1210 Brighton Avenue

Fri, May 26, 2017 at 11:49 AM

EROSION CONTROL PLAN

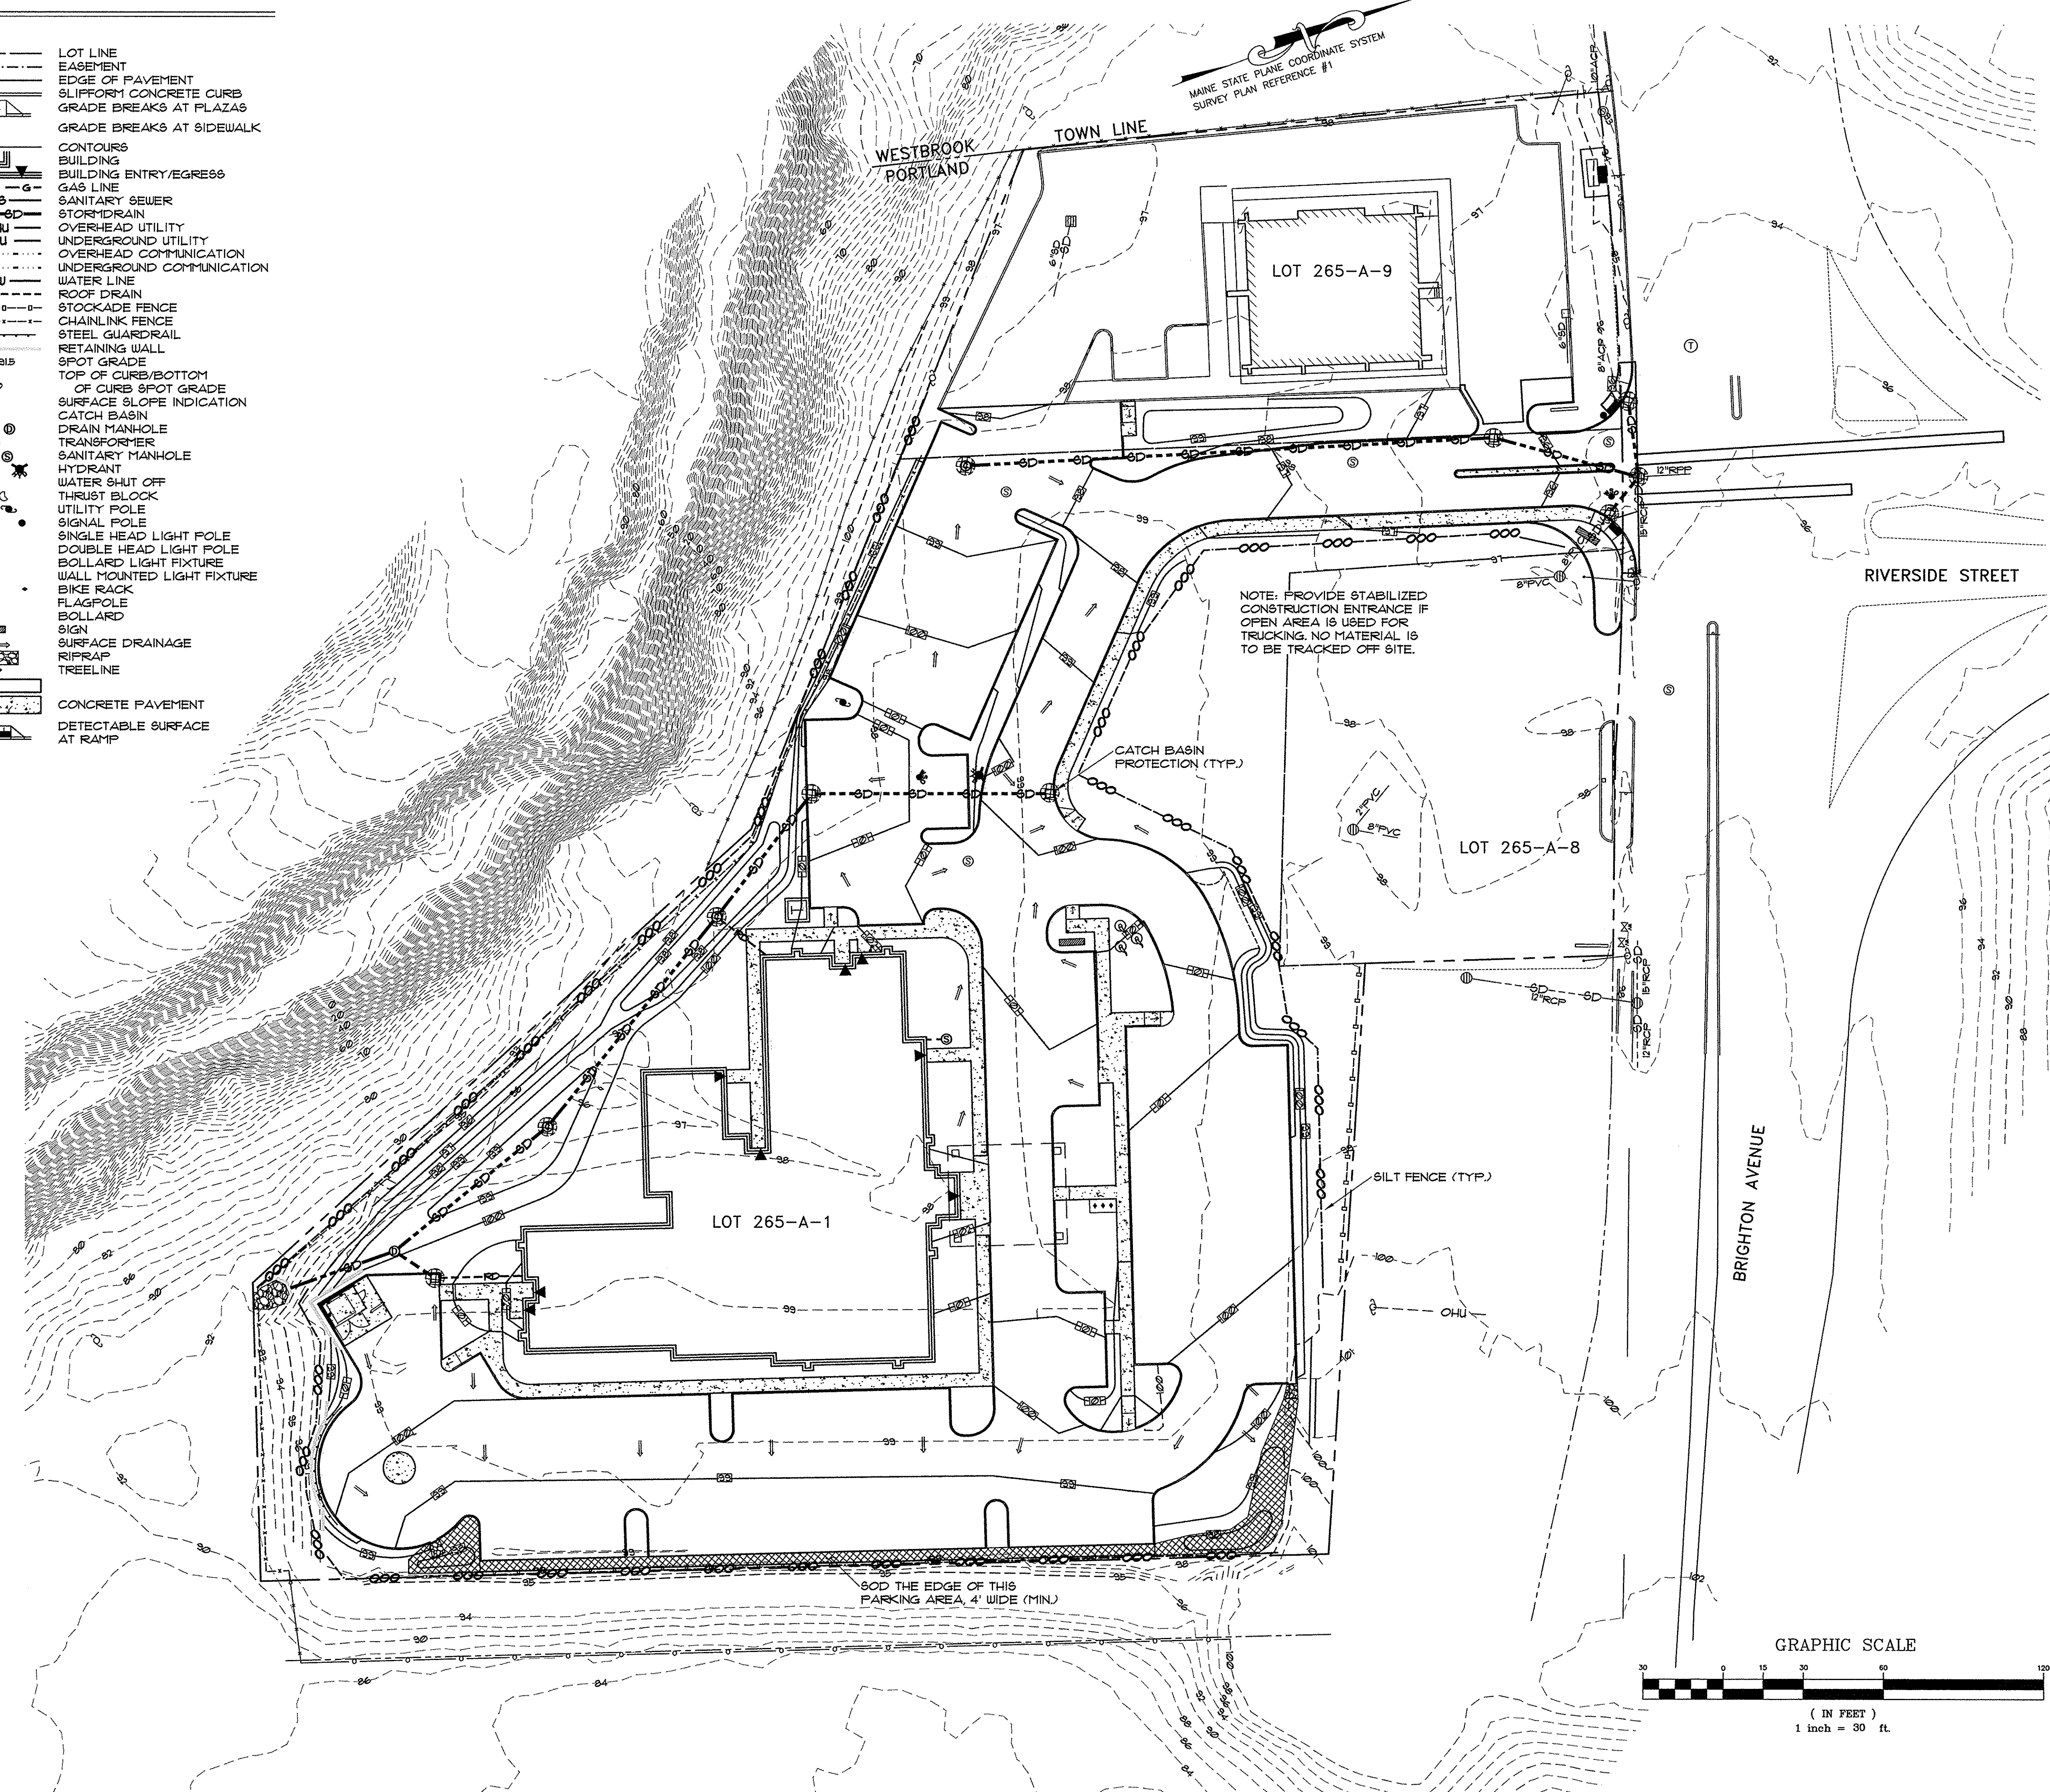
I spoke with Tom Greer. We discussed the stormwater discharge coming from the two curb outlets. They've reviewed the flow to those areas, and determined that additional erosion control is not required. Based on my discussion with Tom, I am OK with the site as shown.
